Appeal Decision

Appeal Ref: APP/R5510/D/21/3285856

139 Bury Street, Ruislip HA4 7TQ

- The appeal is made under section 78 of the Town and Country Planning Act 1990 against refusal to grant planning permission.
- The appeal is made by Mr David Ayonoadu against the decision of the Council of the London Borough of Hillingdon.
- The application Ref 20795/APP/2021/2836, dated 16 July 2021, was refused by notice dated 15 September 2021.
- The development proposed is first floor rear extension, conversion of roof space into habitable use to include front and rear rooflights, alterations to the existing conservatory to form a flat roof single storey rear extension (including external alterations) and new side and rear windows/doors.

Rear Elevation

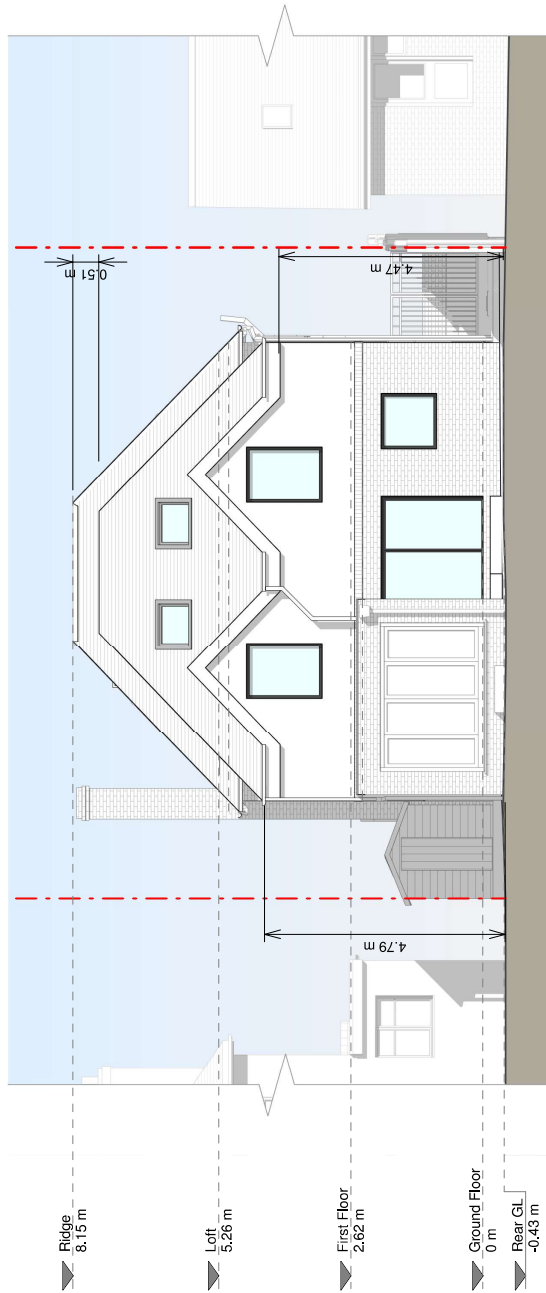
8. The proposed development would introduce a first floor above the existing cat-slide roof to the rear and extend the rear hipped roof slope to provide accommodation in the roofspace. This would take the form of a part crown roof with double gable arrangement set below the ridge of the existing roof. The development makes use of the existing footprint of the ground floor and dwelling.

Part 1² deal with design of new development expecting all developments to be designed to the highest standards. Whilst I accept that the development would span the full width of the dwelling, the extensions would remain within the existing dimensions, including below the ridge of the original roofline. The depth of the extensions would not protrude any further than the existing single storey rear extension and would respect the original hipped roofline, retaining the original character and appearance, albeit with the introduction of the two subservient gables. The Council accepts that the existing roof arrangements are complicated however taking into account the above findings, I do not consider that the proposed development would be top heavy or unacceptably dominant to the existing roof outline or the overall appearance of the dwelling.

13. As described above, the proposal would introduce a roof extension to the main roof and above the existing rear extension. There would be no extension to the depth of the existing footprint, being 3.2m. Both the appeal site and no. 141 are set away from the common boundary. The interface along this boundary is the original two storey dwelling, the single story rear extension with mono-pitched roof, and brick wall to rear conservatory. There are no windows facing the neighbour. The development would introduce additional height to the existing arrangements.

line. Policy DMHD 1 confirms that two storey extensions should not extend into an area provided by the 45 degree line of sight. Whilst there is some concern that the 45 degree line does not confirm compliance with all windows to no. 141, the appeal documents show that even at the closest point of no. 141, the 45 degree line would be breached only marginally at the corner of the development and I see no reason to disagree with this conclusion. I was able to see at my site visit that to the ground floor of no. 141 there was a double window in a single storey element, with a glazed door beyond; and to the first floor a window set back from the boundary to the appeal site.
